Re: Variation to Impacts on Aboriginal Heritage at Yarra Yarra to Holbrook (N4).

I refer to your letter of 3 October 2007 regarding the Hume Highway Duplication Project and proposed variations to impacts on Aboriginal Heritage along the Yarra Yarra to Holbrook section.

STATUS:	DRAWING NO:	REV:
DETAILED DESIGN	NHA-EN-24192007	01

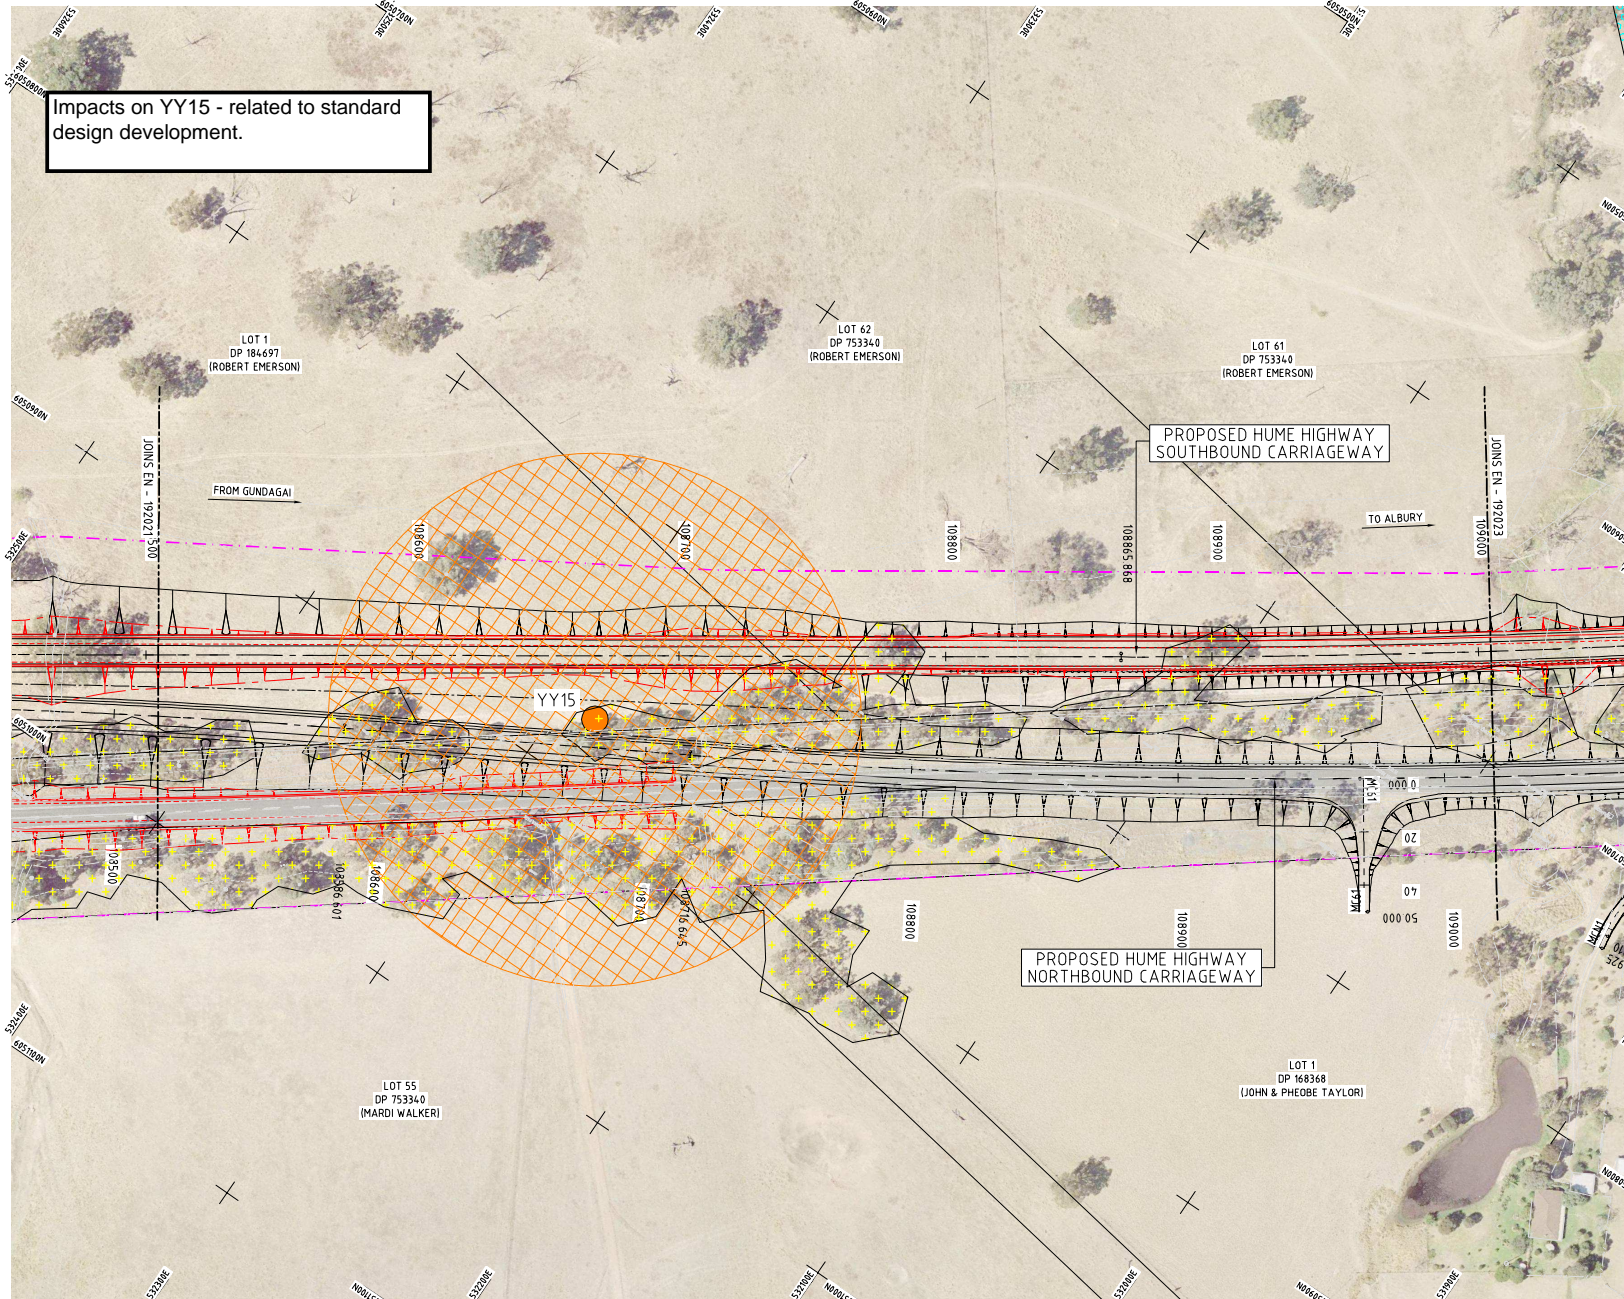
- Increased impacts on sites YY14, YY17, YY18 - As proposed construction impacts to these sites will now increase, DECC endorses the proposed mitigation measure of salvage excavation for these 3 sites. The salvage excavations should be undertaken in accordance with the methodology described in Appendix C of the document Hume Highway Upgrade Duplication Project Aboriginal Cultural Heritage Report Test Excavation Results, Assessment and Management Measures (RTA July 2007).

NORTHERN HUME ALLIANCE		
N4 - YARRA YARRA TO HOLBROOK ENVIRONMENTAL CONSTRAINTS PLAN		
STATUS: DETAILED DESIGN	DRAWING NO: NHA-EN-24192022	SHEET 22
	REV: 01

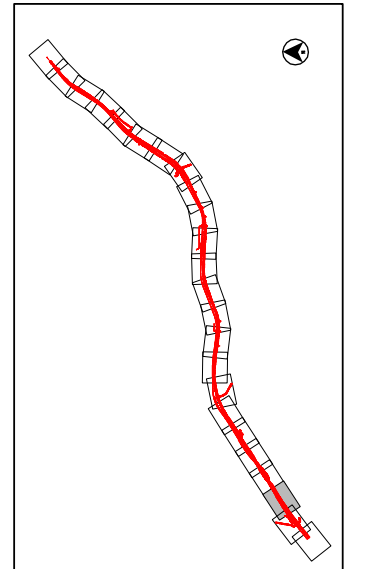
- New impact on YY15 – As this site will now be impacted by construction activities, DECC endorses the proposed mitigation measure of a surface collection of this site. The surface collection should be undertaken in accordance with the methodology described in Appendix C of the document Hume Highway Upgrade Duplication Project Aboriginal Cultural Heritage Report Test Excavation Results, Assessment and Management Measures (RTA July 2007).
